Viking CCS Pipeline

9.41 Design Changes 5 to 8: Environmental Technical Note

Document Reference: EN070008/EXAM/9.41

Applicant: Chrysaor Production (U.K.) Limited,
a Harbour Energy Company
PINS Reference: EN070008
Planning Act 2008 (as amended)
The Infrastructure Planning (Applications: Prescribed Forms
and Procedure) Regulations 2009 - Regulation 5(2)(q)
Date: June 2024

KEY SHEET

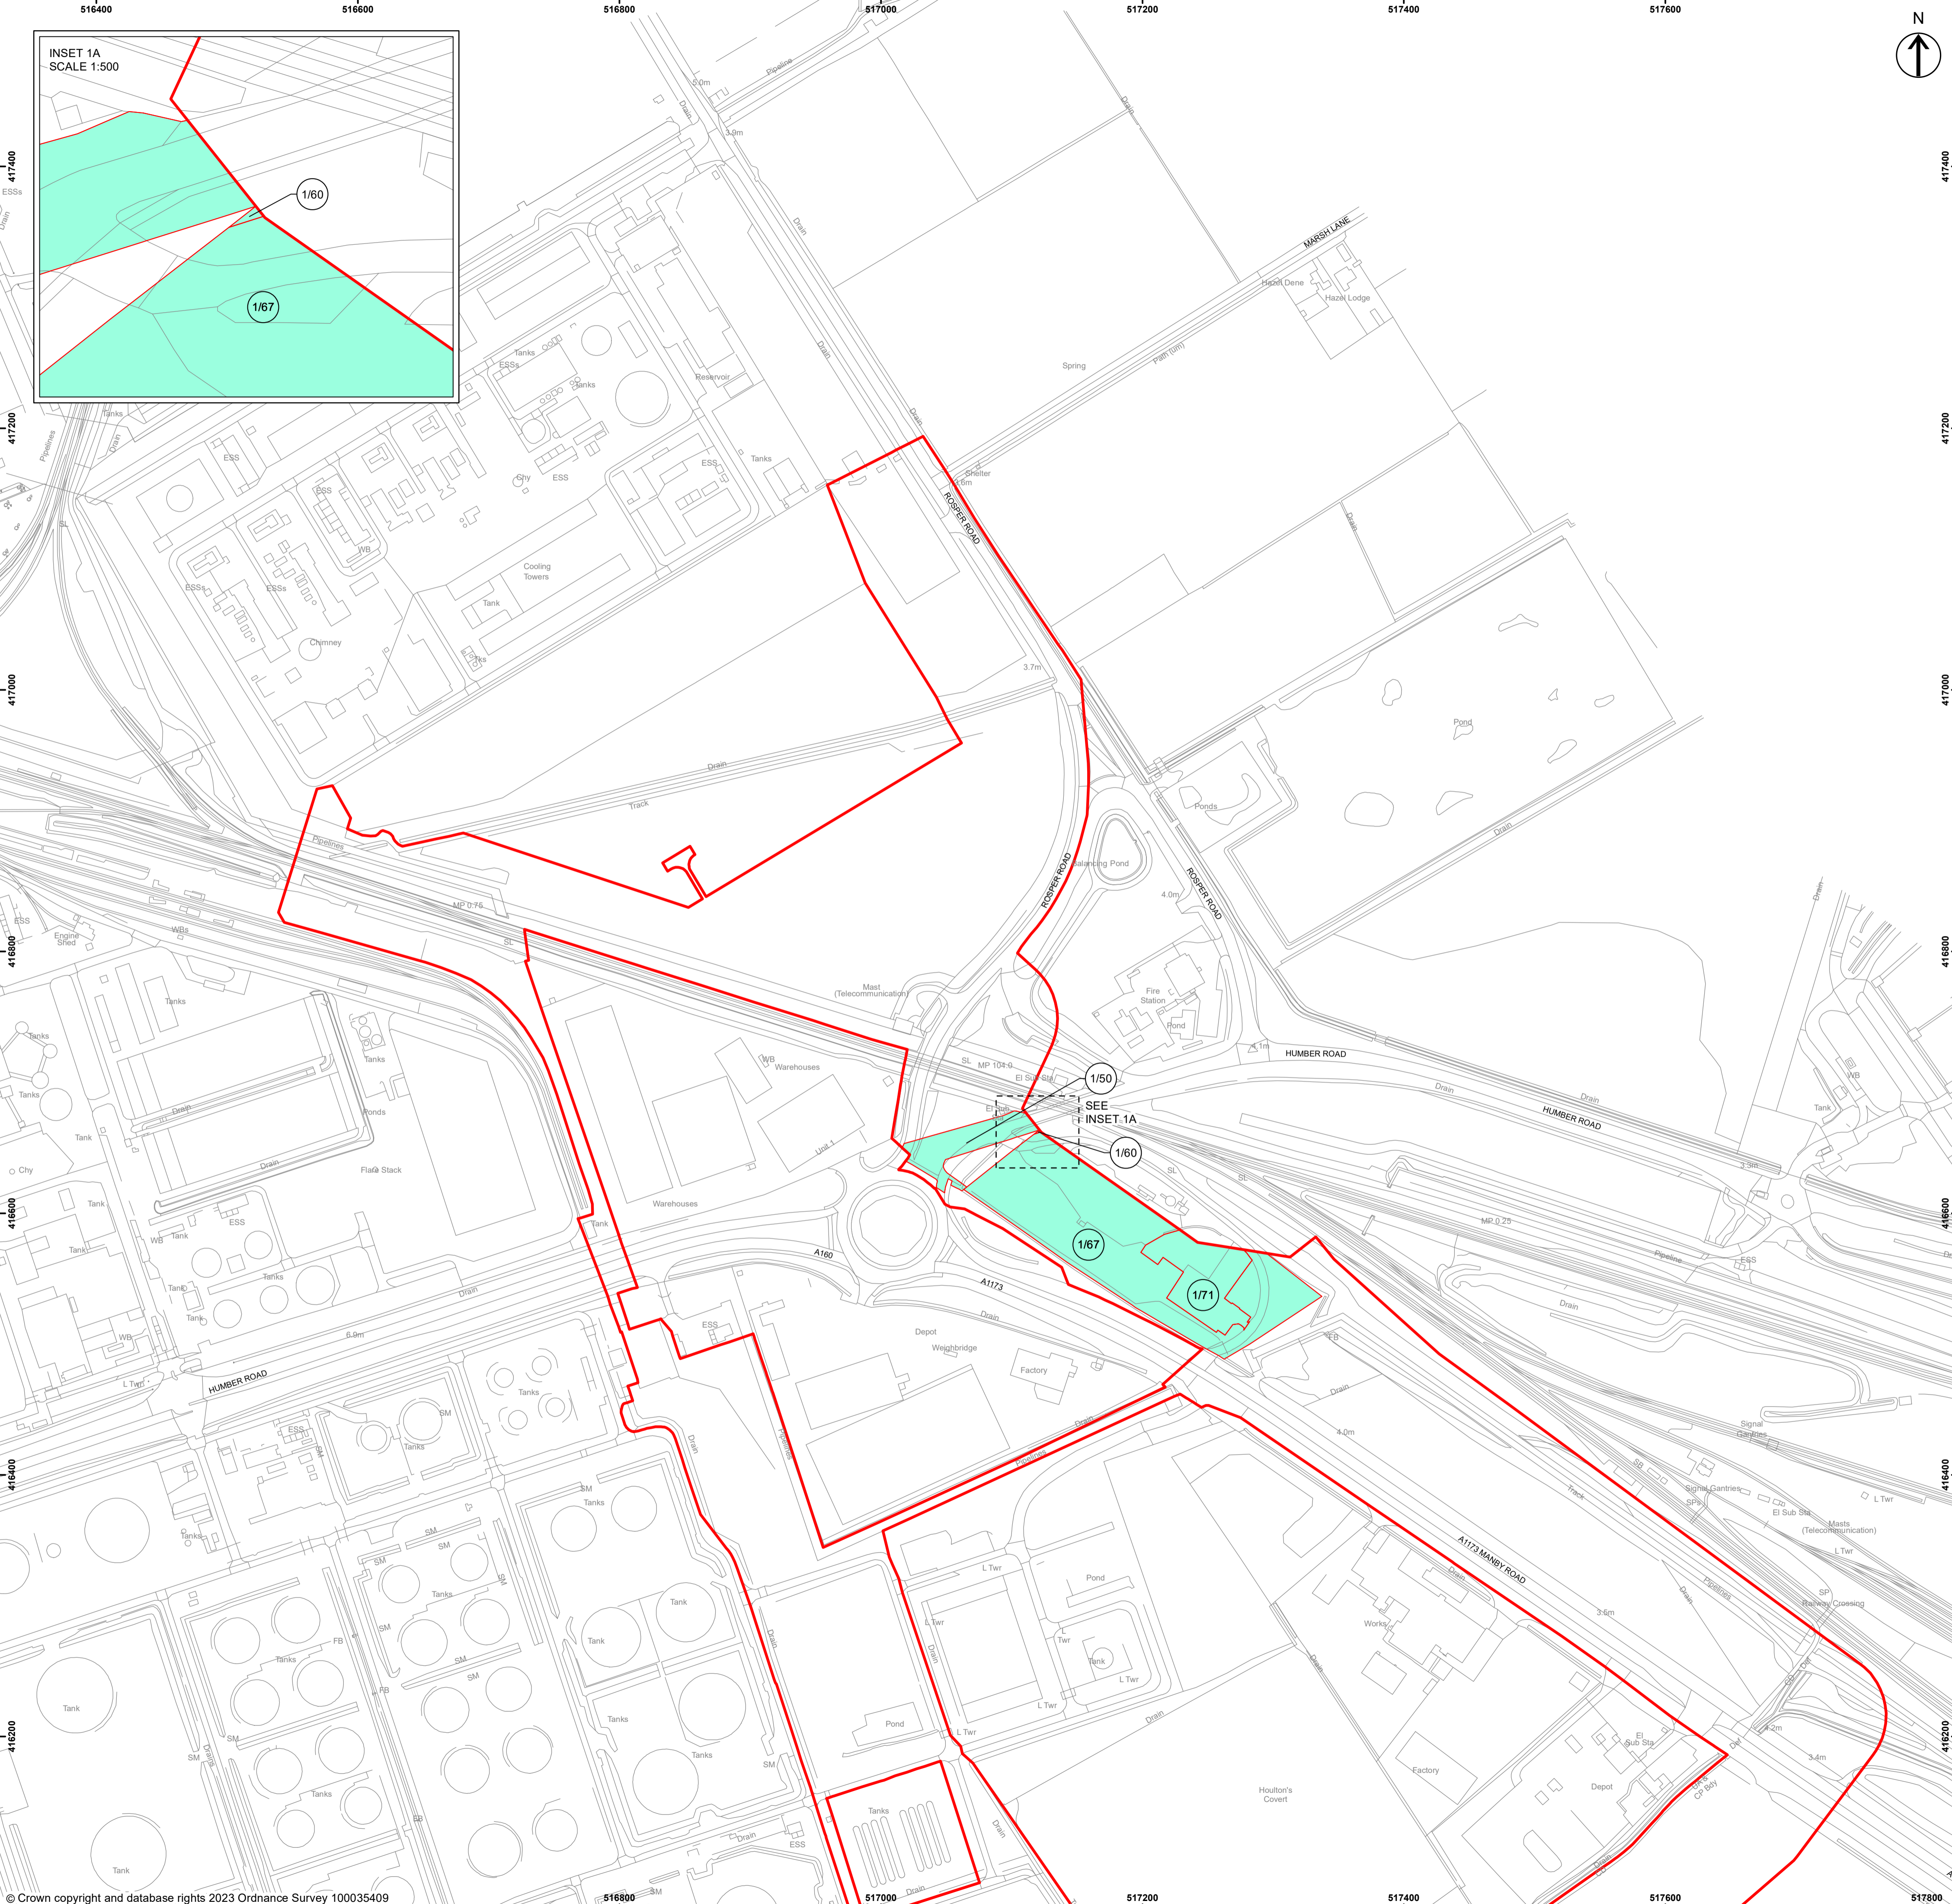
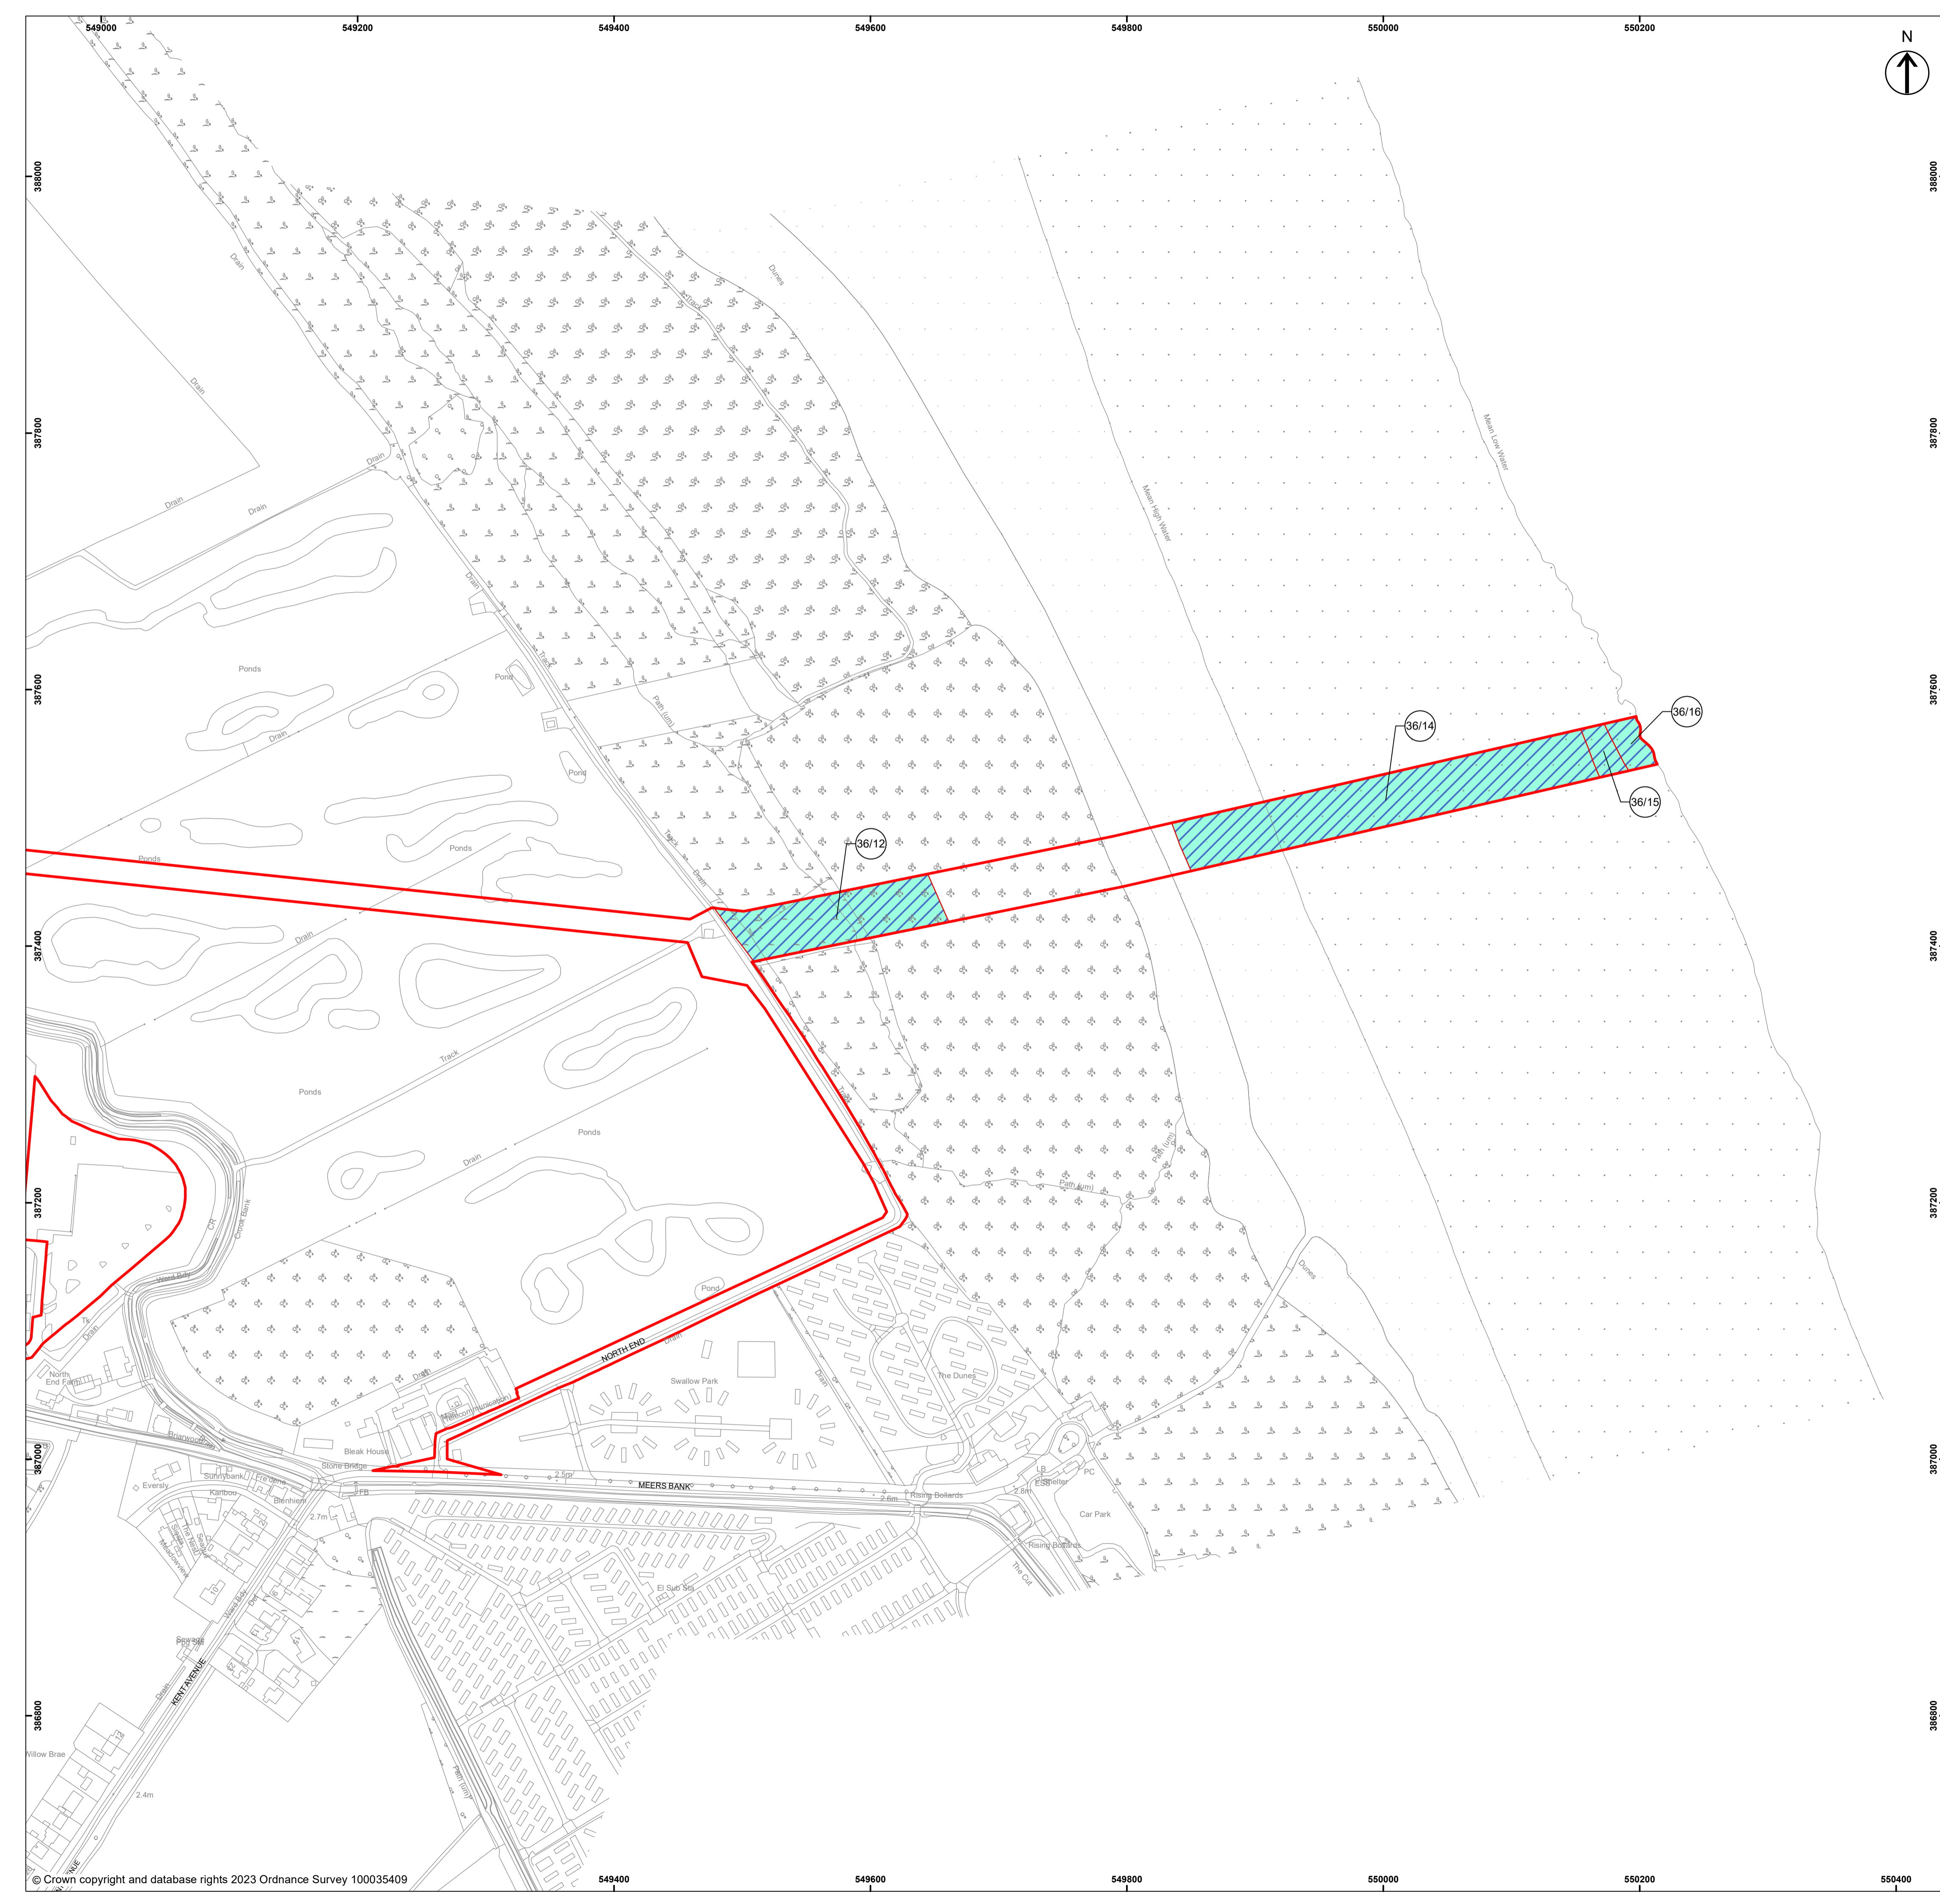
- 2.3.2 The changes would also result in the removal of plots 35/8, 35/9, 35/10, 35/11 and 35/13 from the Land Plans. The nature of rights sought over plots 35/14 and 35/15 would also be amended from seeking permanent acquisition to seeking permanent acquisition of the subsurface only. The change would reduce the area of land included in the Order Limits and would not engage any new land interests. No additional land outside of the current Order Limits would be required.
